# Pres Center on Louisiana

## Administrative Amendment Request

Project #PR 2018-001579      SI-

Transportation Development Comments:

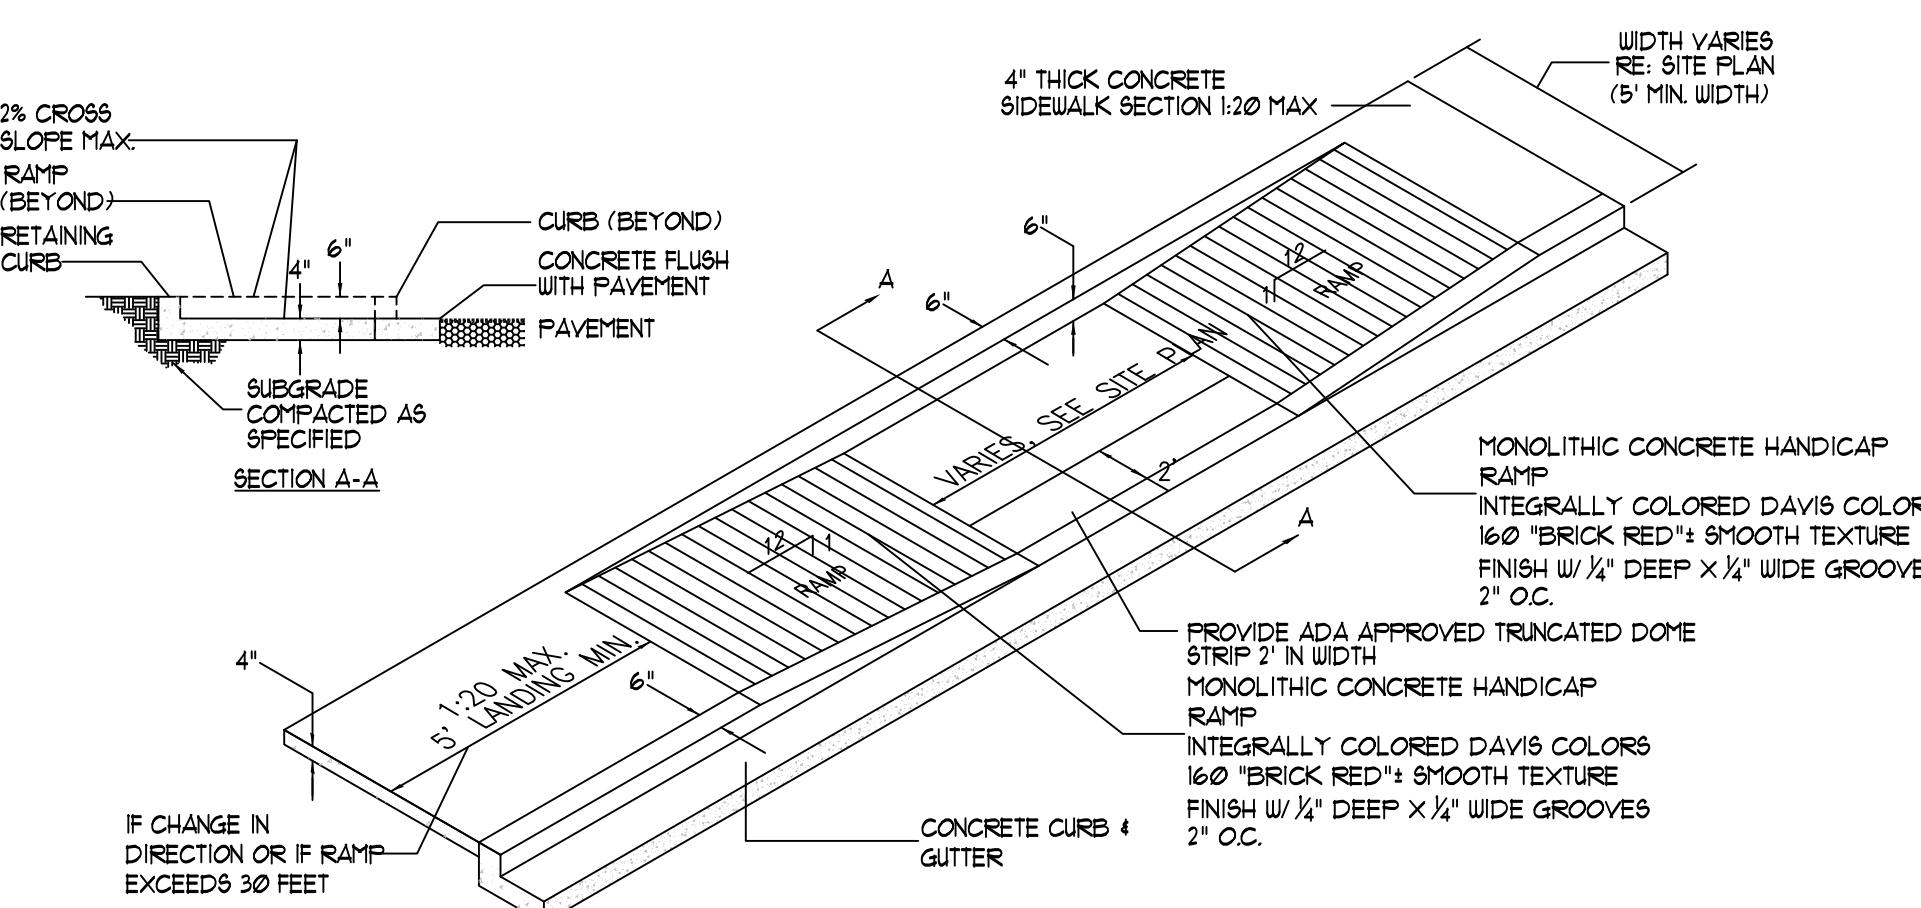
- Platting is required prior to building permit.
- Fire Marshall Approval and Solid Waste Approval is required prior to Transportation's approval.
- There is a concrete joint detail for the northern wall but not a wall cross-section provided for the number referenced on the site plan. **The cross section is A1/AS101**
- Adjust sight distance triangle locations to match standards in DPM. The mini sight triangle is shown behind the sidewalk. Adjust landscaping if needed. **They have been adjusted.**
- Label "MC" in back of motorcycle spaces and "Compact" in back of compact spaces. **Labels have been added.**
